From: Thomas Callaway
Sent: 16 September 2015 16:31
To: Planning.Responses
Subject: RE: Planning Consultation on: A/113/15/PL

Engineers comments in respect to surface water drainage:

APPLICATION NO: A/113/15/PL

Description of Works: Demolition of "Spinney" and "Burberry House" and erection of two-storey hotel annexe with associated car parking. Re-Submission following A/50/15/PL

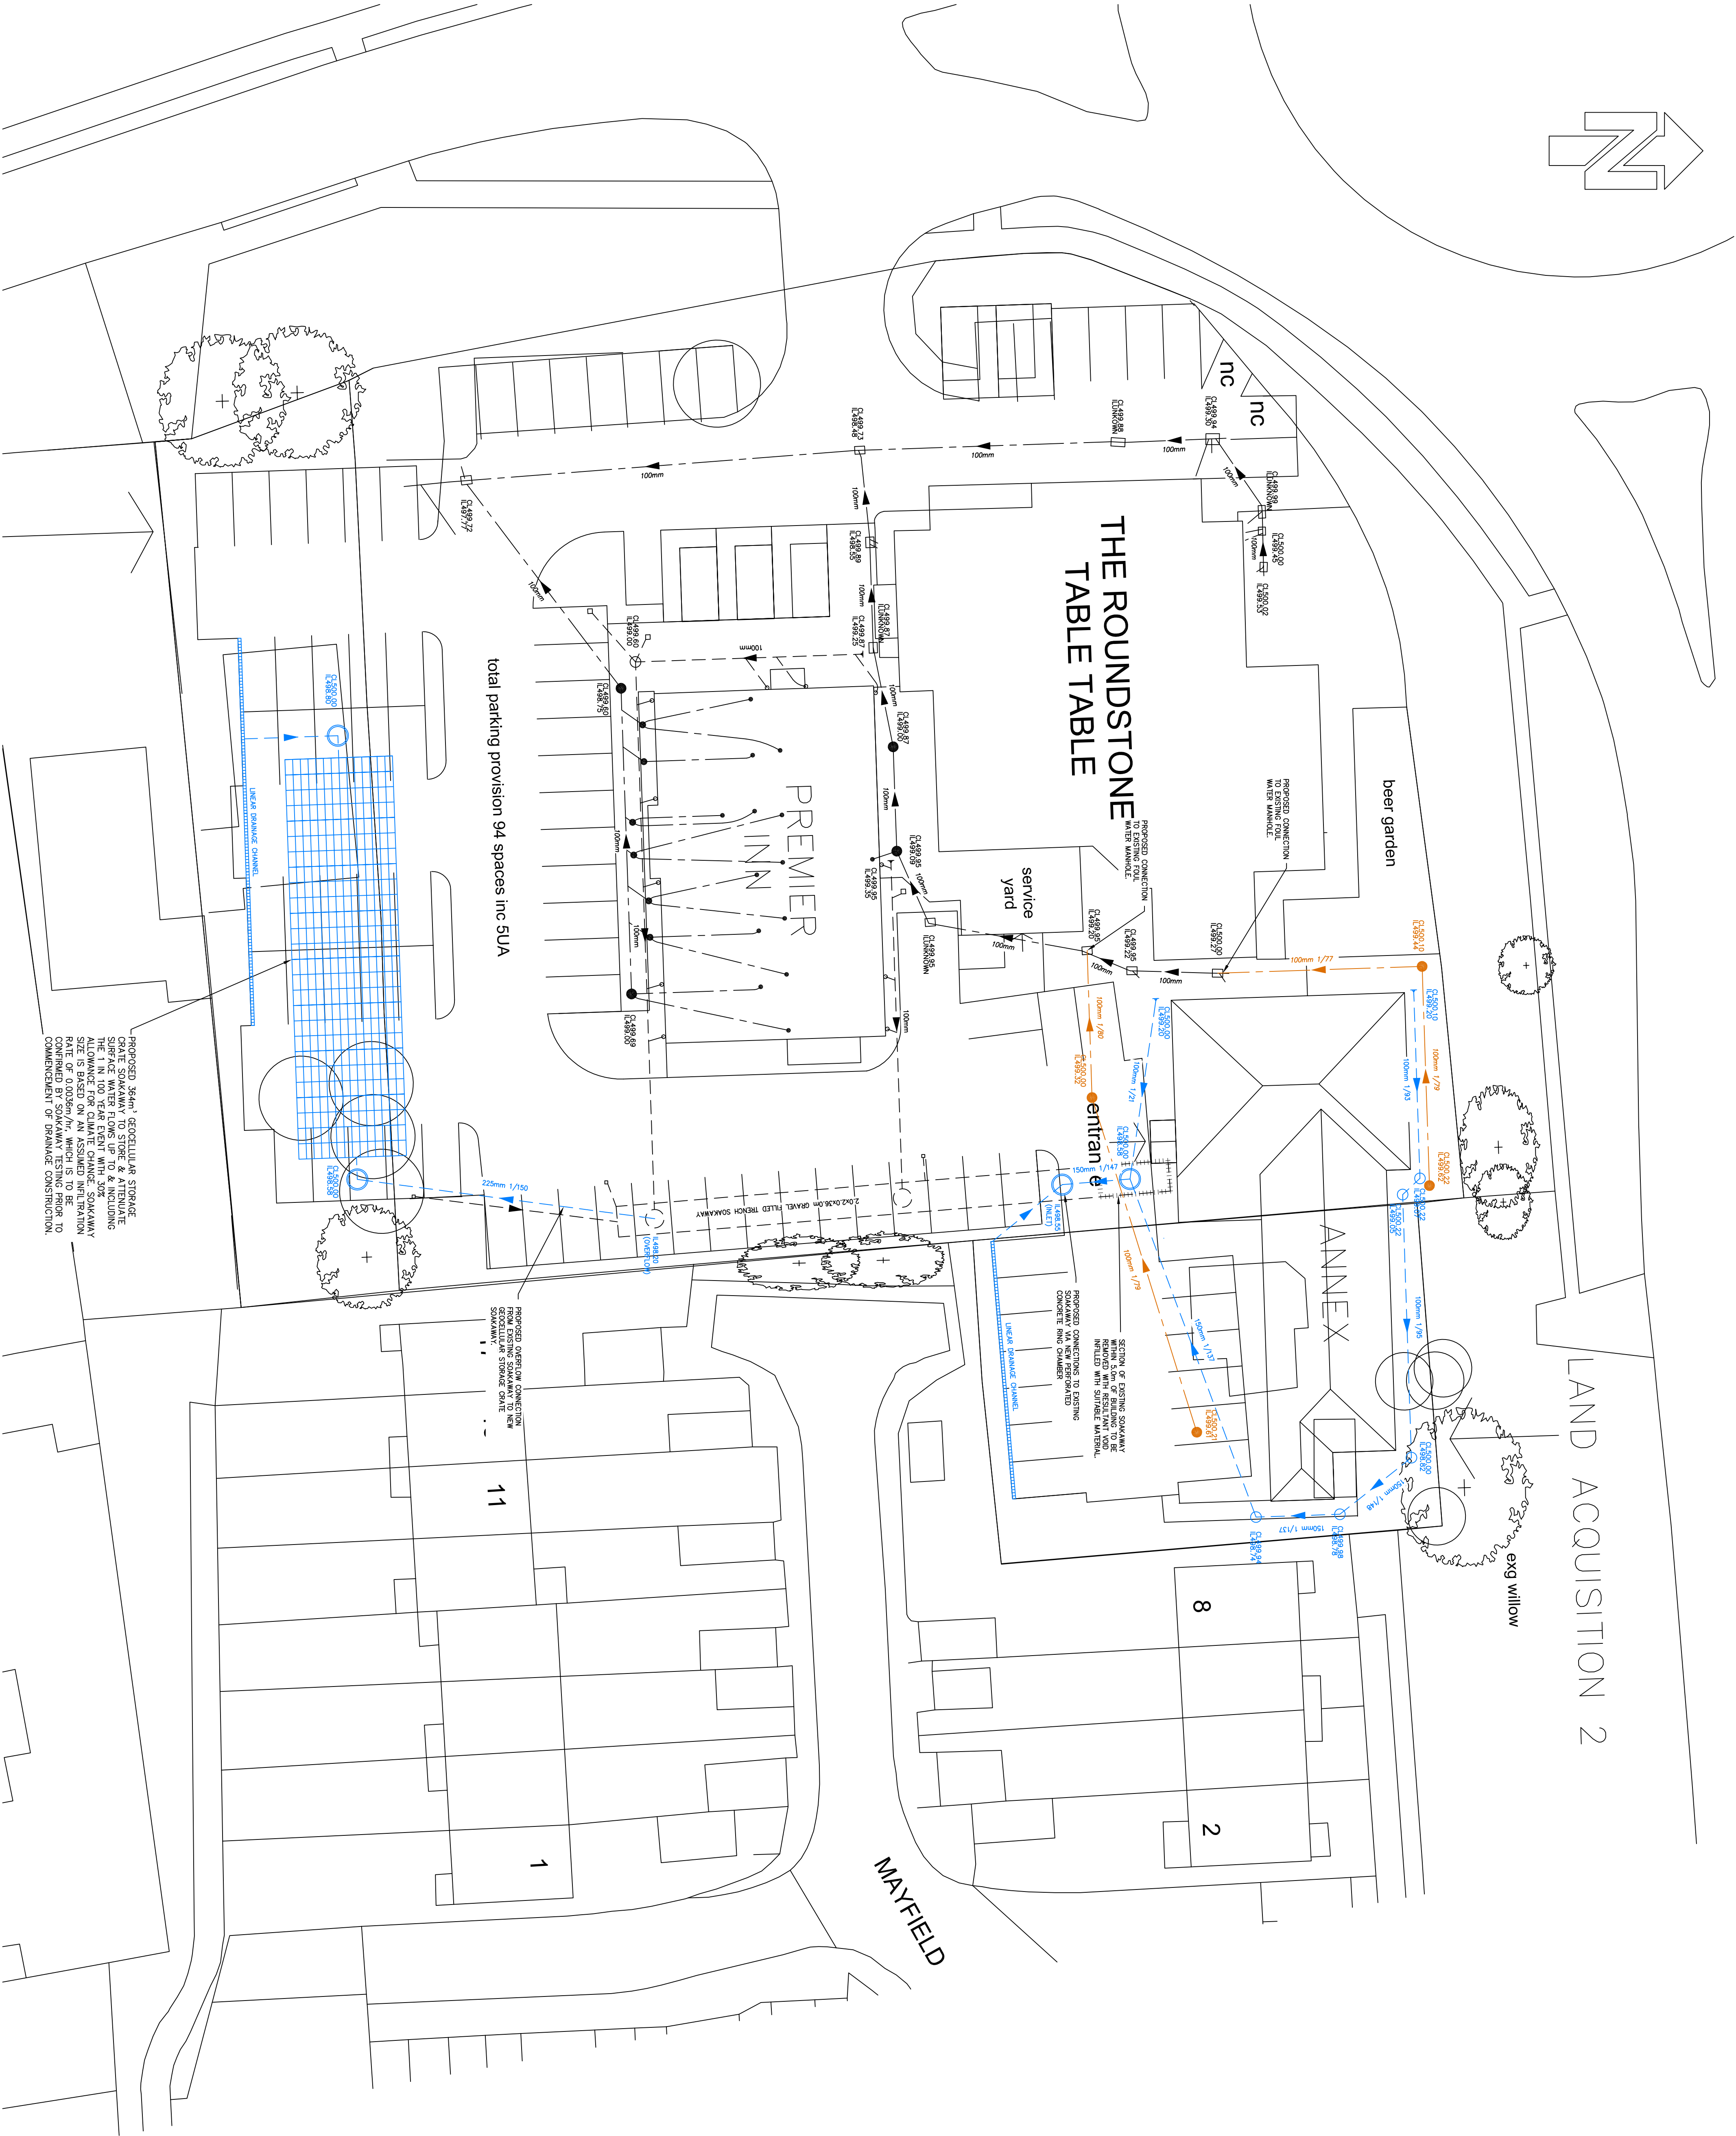
The applicant states that surface water will be discharged to soakaways. A new soakaway serving the proposed development is to be constructed beyond an existing soakaway. A trial pit should be dug in the existing soakaway to ensure it is functioning correctly, with silt traps added prior to each soakaway as necessary. Also the proposed soakaway location is the site of a building – the remnants of foundations etc and compaction of soil may lead to poor soakage rates so it may be beneficial to relocate the soakaway away from the site of the building to be demolished.

Please apply standard conditions ENGD2A.

Infiltration rates for soakage structures are to be based on percolation tests undertaken in the winter period and at the location and depth of the proposed structures. The percolation tests must be carried out in accordance with BRE 365, CIRIA R156 or a similar approved method and cater for the 1 in 10 year storm between the invert of the entry pipe to the soakaway, and the base of the structure. It must also have provision to ensure that there is capacity in the system to contain below ground level the 1 in 100 year event plus 30% on stored volumes, as an allowance for climate change. Adequate freeboard must be provided between the base of the soakaway structure and the highest recorded annual groundwater level identified in that location.

Any SuDS or soakaway design must include adequate groundwater monitoring data to determine the highest winter groundwater table in support of the design. The applicant is advised to discuss the extent of groundwater monitoring with the Council's Engineers. Supplementary guidance notes are also enclosed for information.
